RESPONSE TO SUBMISSIONS

Figure 1.1 – Landscape Plan (source: *Arcadia Landscape Architecture*)

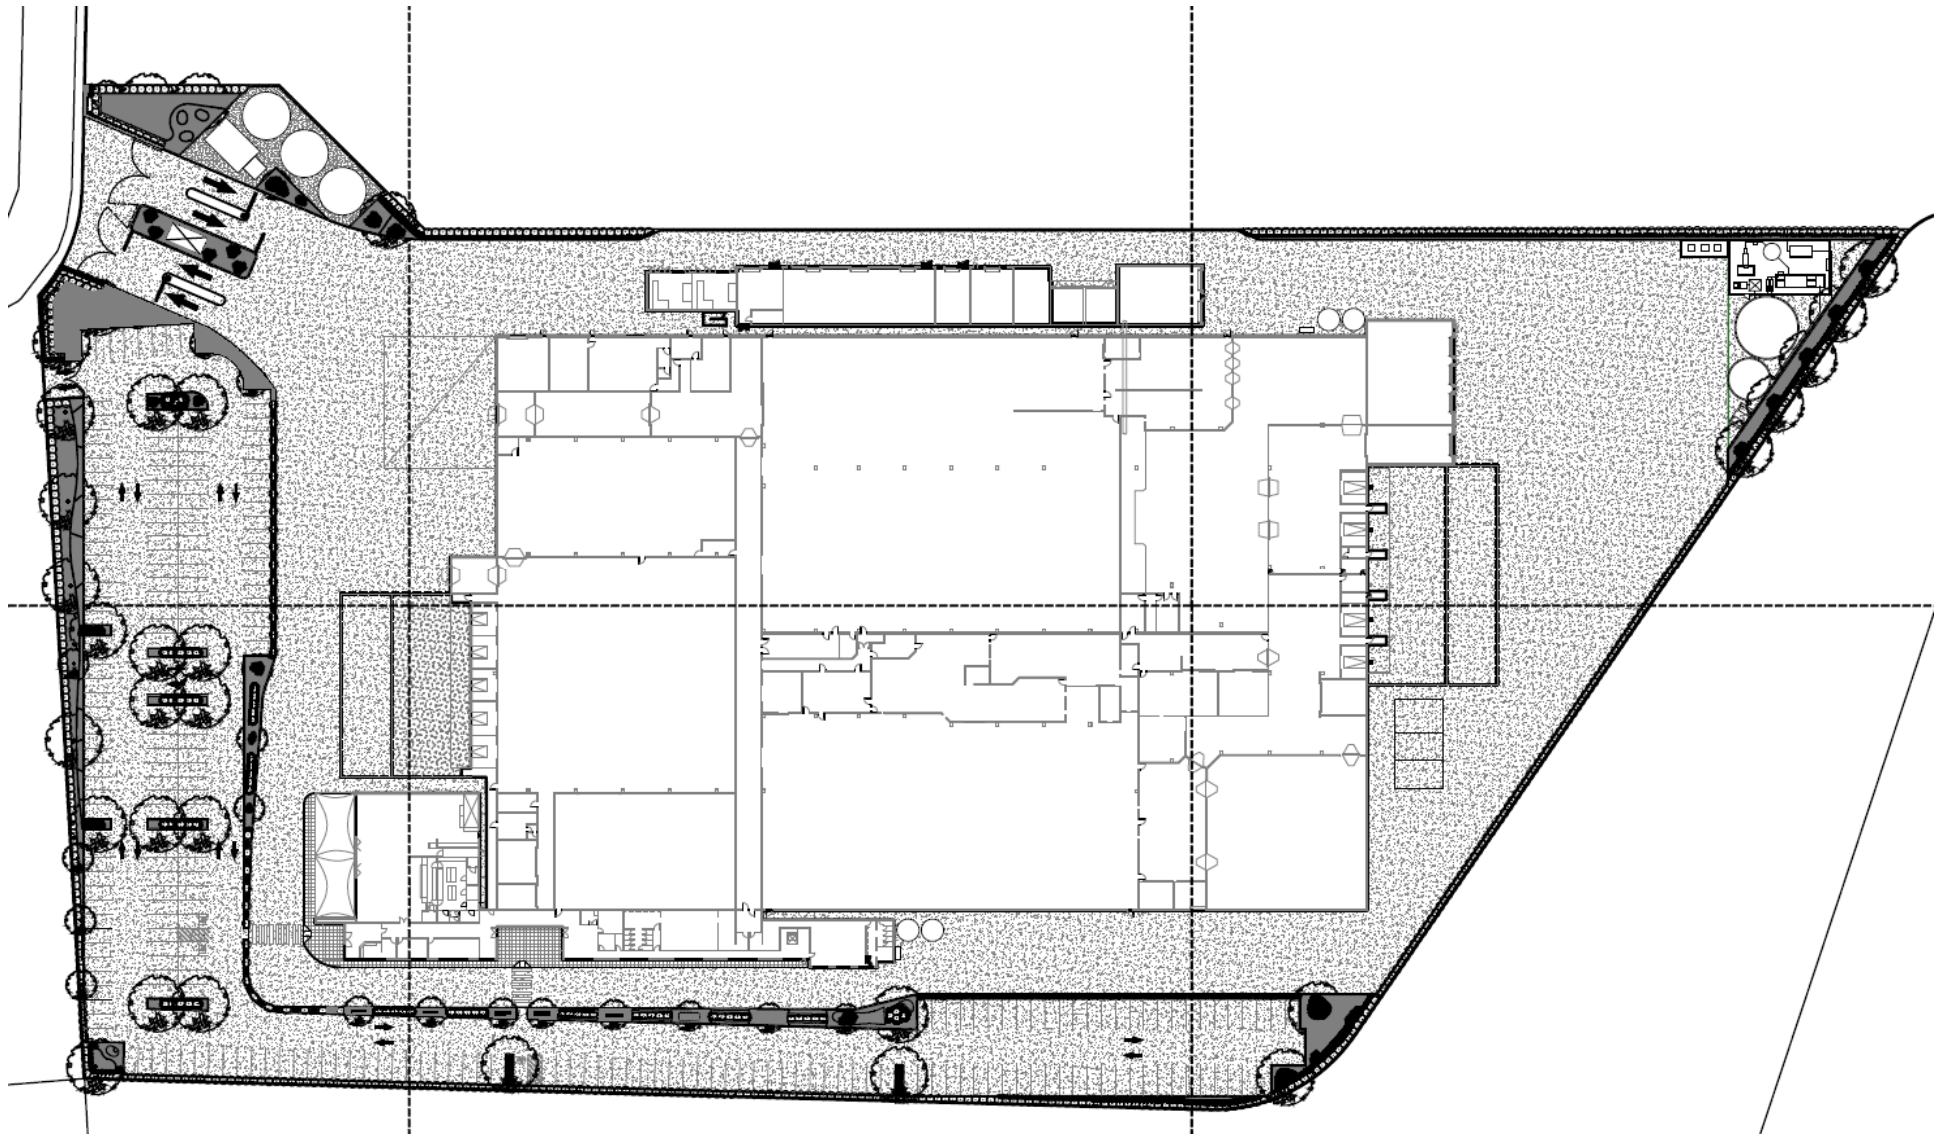
Issue	Response
Penrith City Council	
Landscaping The landscaping provisions to the western and southern boundaries have significantly improved.	The proposed landscaping is satisfactory to Council.
Architectural Merit of the Proposed Building Council is satisfied that the bulk, scale and character of the development will be compatible with other developments in the precinct but suggest the parapet finishes appears busy and resembles "barcode". This could be simplified to better integrating with lower portion of the elevation and highlight areas of interest by incorporating architectural elements.	Nicholas & Alexander Architects consider the design of the building 'appropriate in dealing with the proportions of the building, creating interest and a language that contributes to the greater urban environment.' Refer to their letter in Attachment 1. The elevation should also be read in conjunction with the screen landscaping to be provided to the street frontage which provides a suitable landscaped setting for the development.
